The Secretary
NSW Department of Planning, Industry and Environment

27 May 2021

I refer to the Department's below email of 10 May 2021 regarding the notice of exhibition of the Environmental Impact Statement (EIS) for State Significant Development SSD-8873789 the New Epping South Primary School (Concept and Stage 1) for 'Staged Concept Development Application comprising demolition works and the construction of new buildings to cater for an enrolment capacity for up to 1,000 students' at 86 Chelmsford Avenue, Epping (Lot 1 DP 582172) in the City of Parramatta LGA. Submissions need to be made to the Department by 23 June 2021.

Figure 6-1: Plant Locations

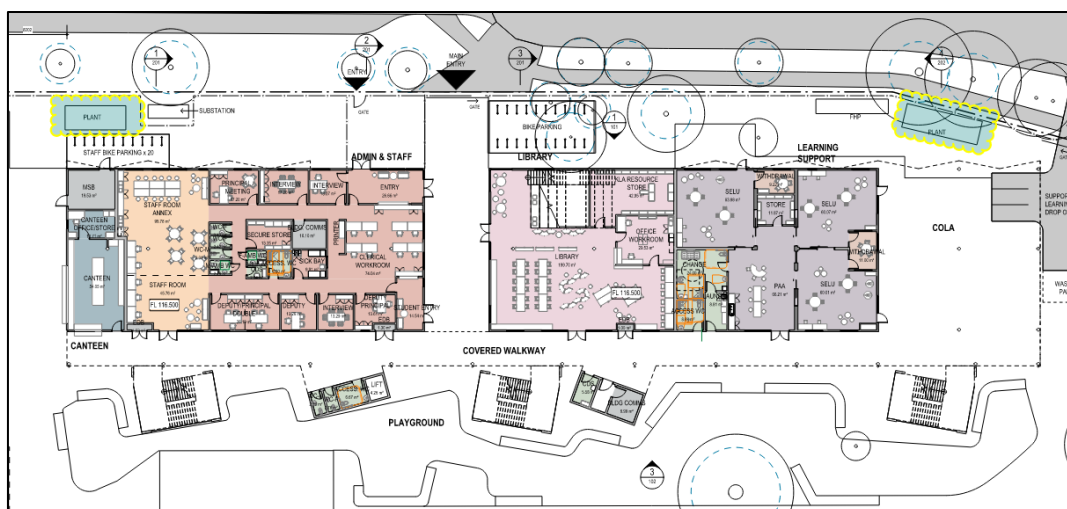
As part of the further Noise Impact Assessment consideration should also be provided to the new padmount substation required to facilitate the proposed development. The transformers in substations may emit a hum – especially when under heavy load say in the summer peak when use of air conditioning is at its highest. The noise is usually not perceptible enough to be regarded as disruptive and/or to the point where amelioration measures are required. As noise levels, frequency and timing can vary and people perceive sounds differently, to minimise any potential exposure to intrusive noise, the siting towards the electricity infrastructure of less sensitive uses or parts of the building not regularly occupied is recommended.

As shown in the following extract of the Noise Impact Assessment the substation is not indicted as being potentially noise generating equipment.

Figure 6-1: Plant Locations
